From: Chris Moore [REDACTED]
Sent: 31 October 2017 11:25
To: Simon Davis
Cc: 'Isitt, Matt, Vodafone Group'
Subject: RE: FP/261/17/HH 2 Second Avenue, Felpham

From: Simon Davis [REDACTED]
Sent: 27 October 2017 10:04
To: 'Chris Moore' [REDACTED]
Subject: FP/261/17/HH 2 Second Avenue, Felpham

PROPOSED FIRST FLOOR PLAN

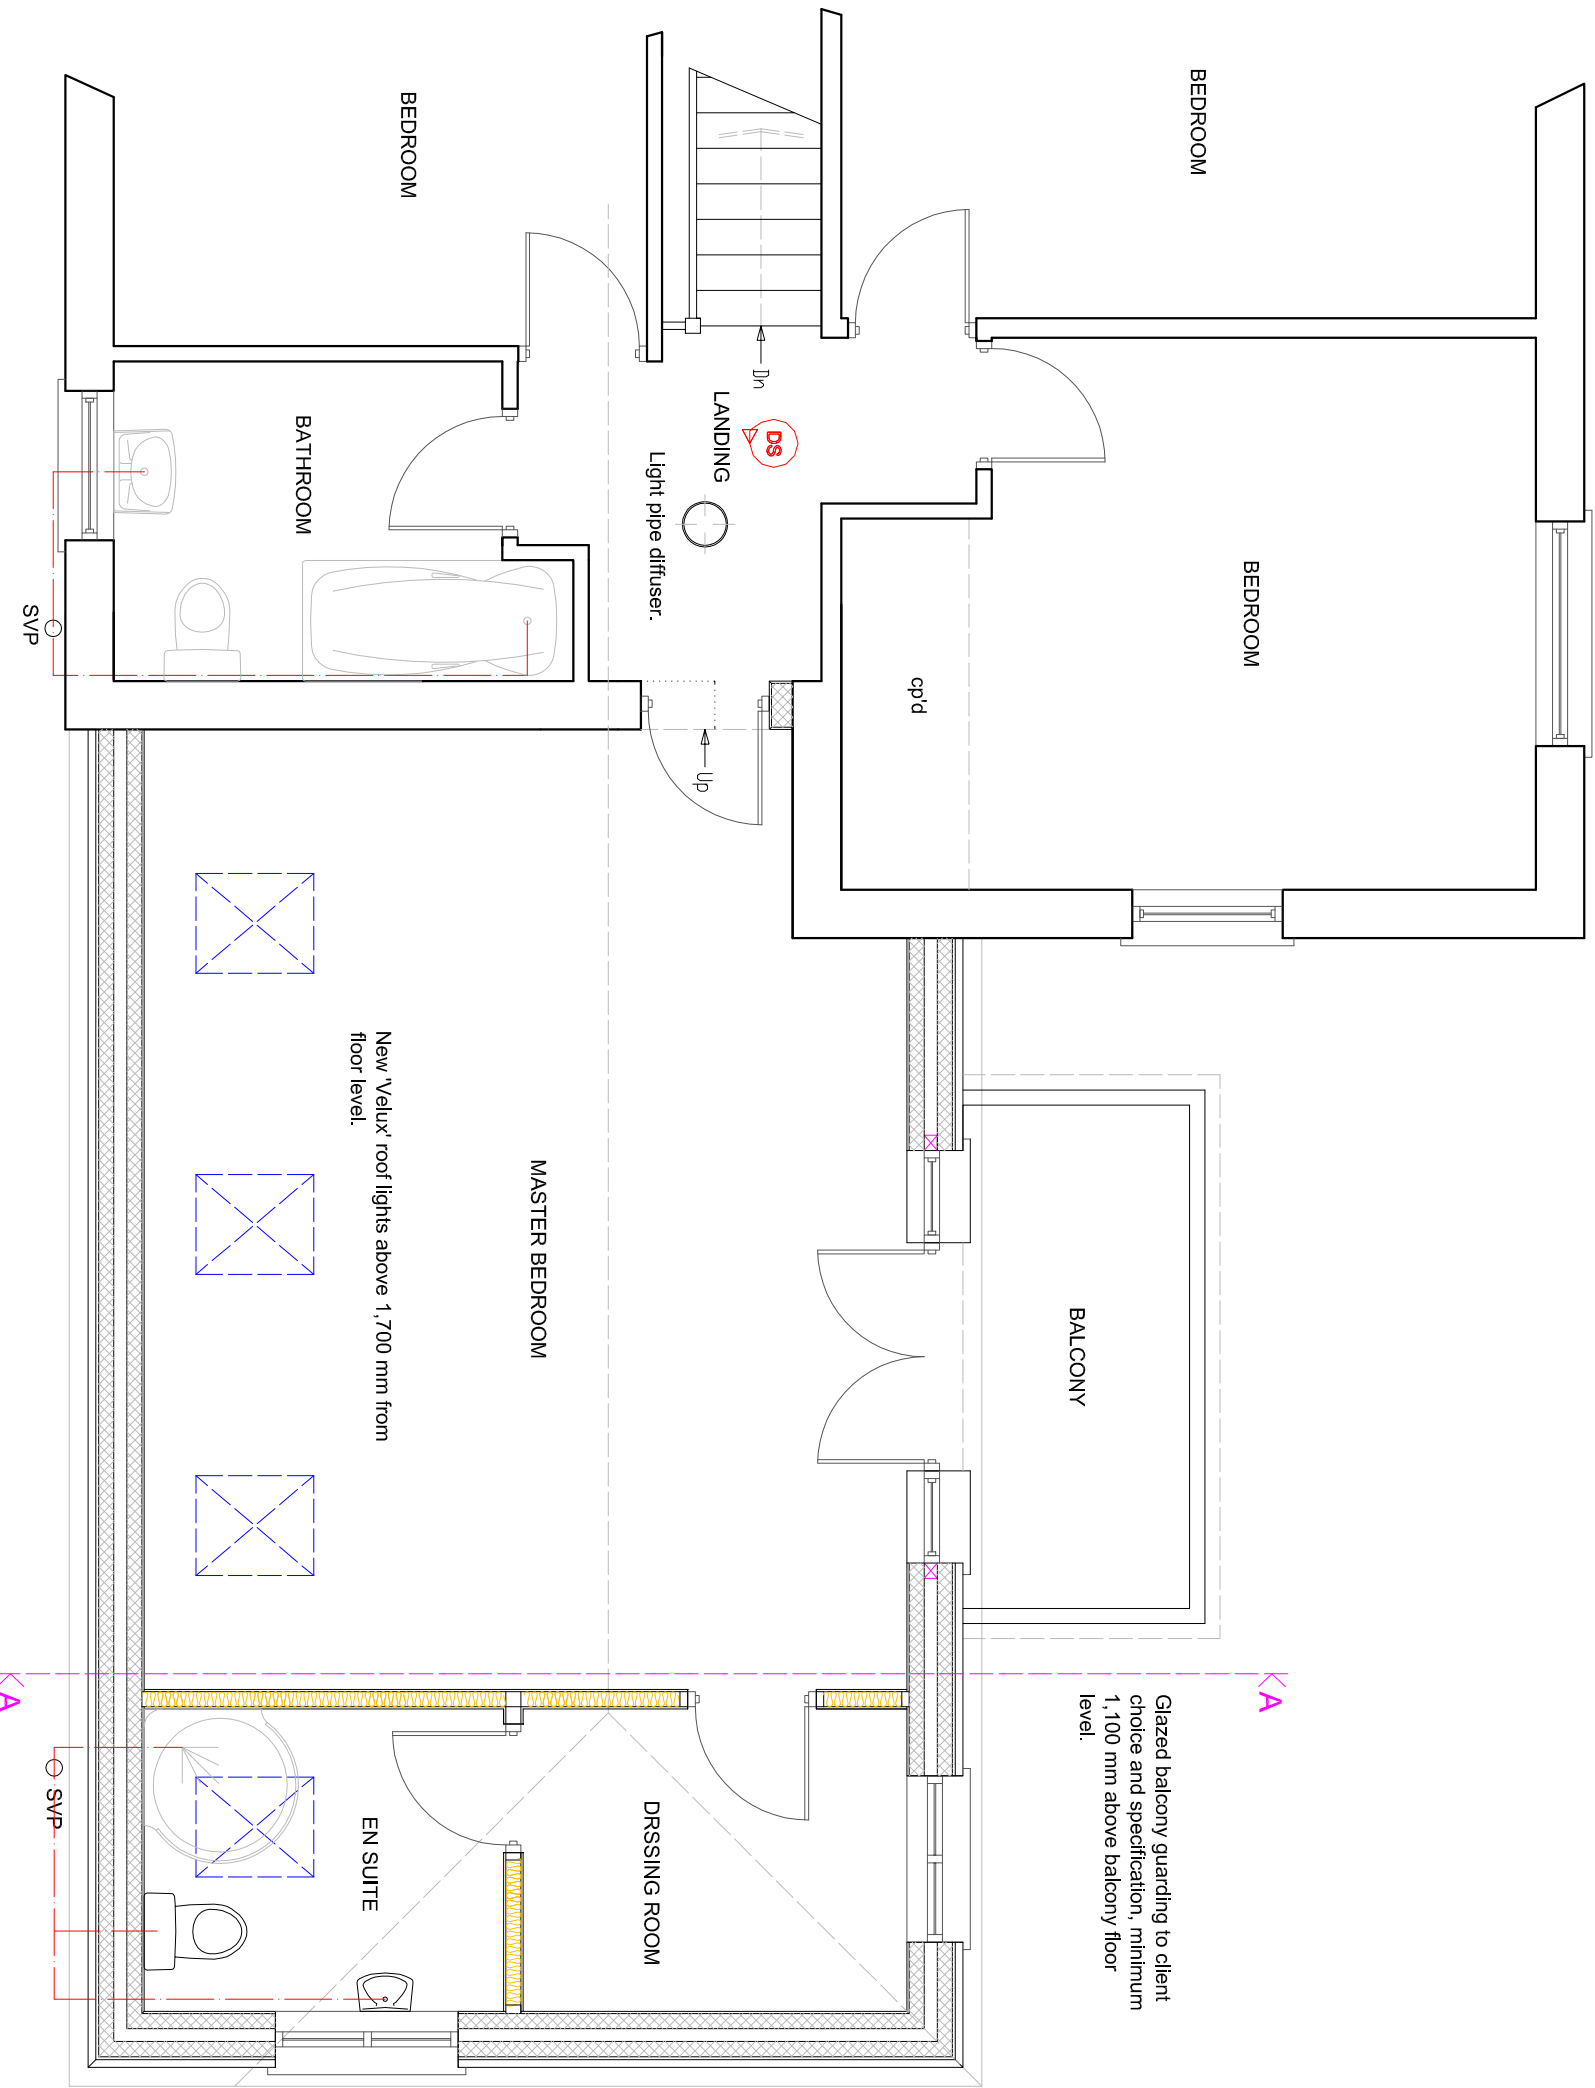
I've just received this application and taken a look at it. I don't like the proposed rear balcony as this will allow clear views over the immediate rear patio/garden area of the proposed new dwelling. This would be an unacceptable arrangement in respect of the amenities of future occupiers. This would only be acceptable if permission was rescinded for the new dwelling. I have no immediate concerns with the front garage extension or the first floor rear extension itself. Would your clients remove the balcony from the plans?

In light of your comments the client has instructed me to remove the balcony and I have now removed this from the plans and replaced with a flush 'Juliet' balcony guarding -- copies of all relevant documents are attached.
